CITY OF PORTLAND BUILDING PERMIT

Located At 184 PEARL ST

Job ID: 2011-10-2374-NEWCOM

has permission to Construct a new 54 unit residential building w/parking on ground floor provided that the person or persons, firm or corporation accepting this permit shall comply with all of the provisions of the Statutes of Maine and of the Ordinances of the City of Portland regulating the construction, maintenance and use of the buildings and structures, and of the application on file in the department.

Drawing file: Architecture / A200 - EXTERIOR ELEVATIONS.pdf

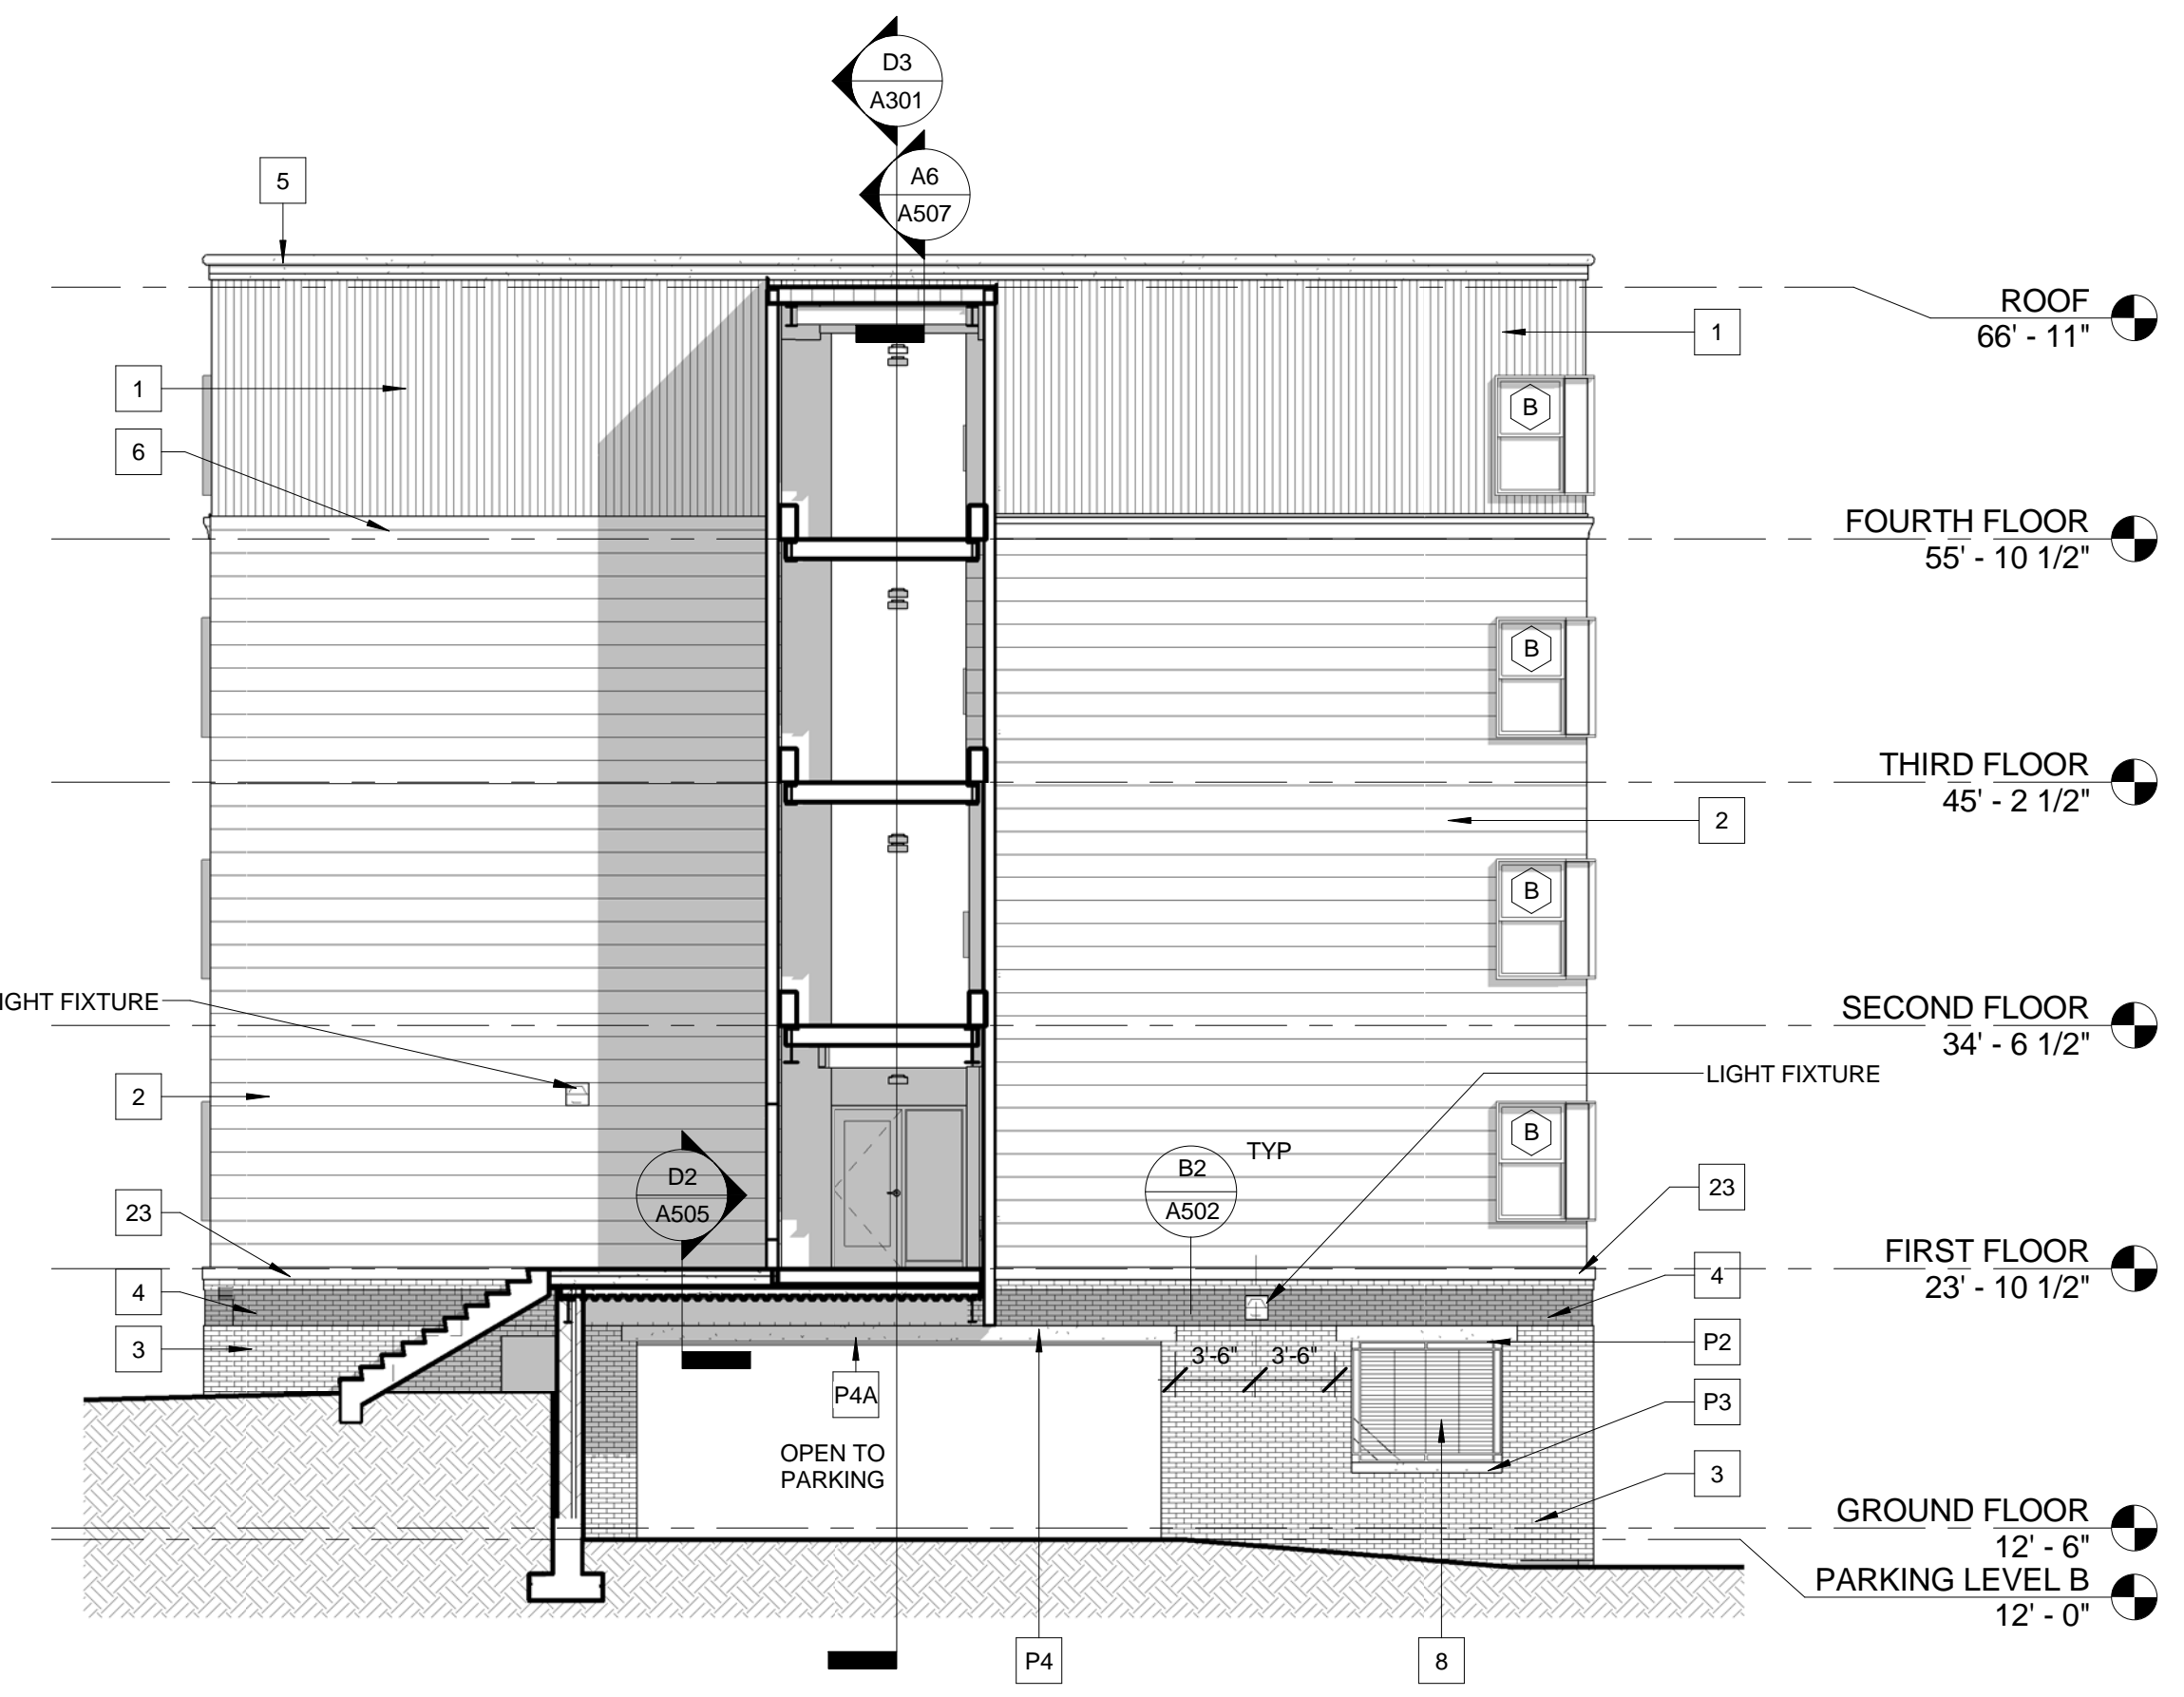
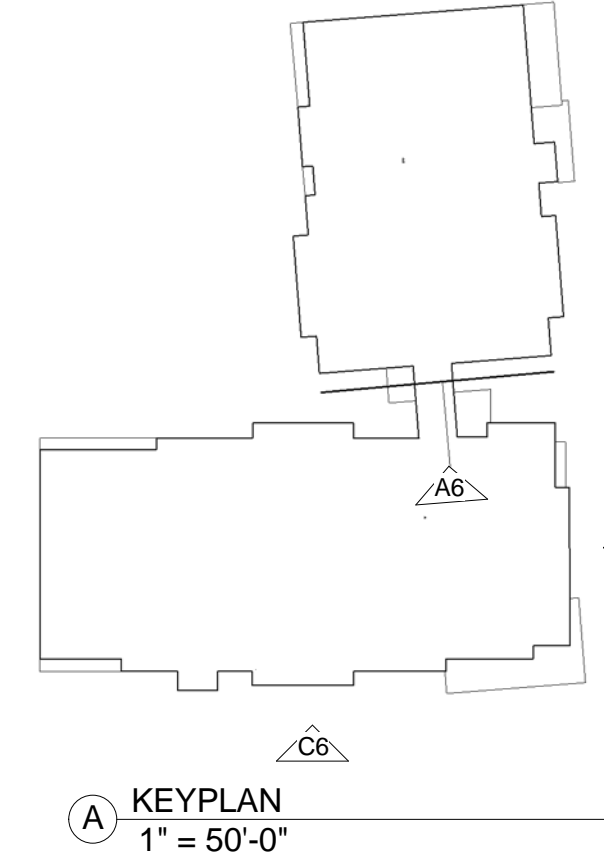
5.	Safety Glazing for windows - Indicate windows at stairwells to have safety glazing	See attached elevations for clarification
6.	Clarify locations of safety glazing at Link curtainwall.	Glazing at the link shall comply with IBC Section 2406. Since all single panes of non-spandrel glass are greater than 9 sq.ft., it will all be required to be tempered safety glazing. See attached elevations for clarification
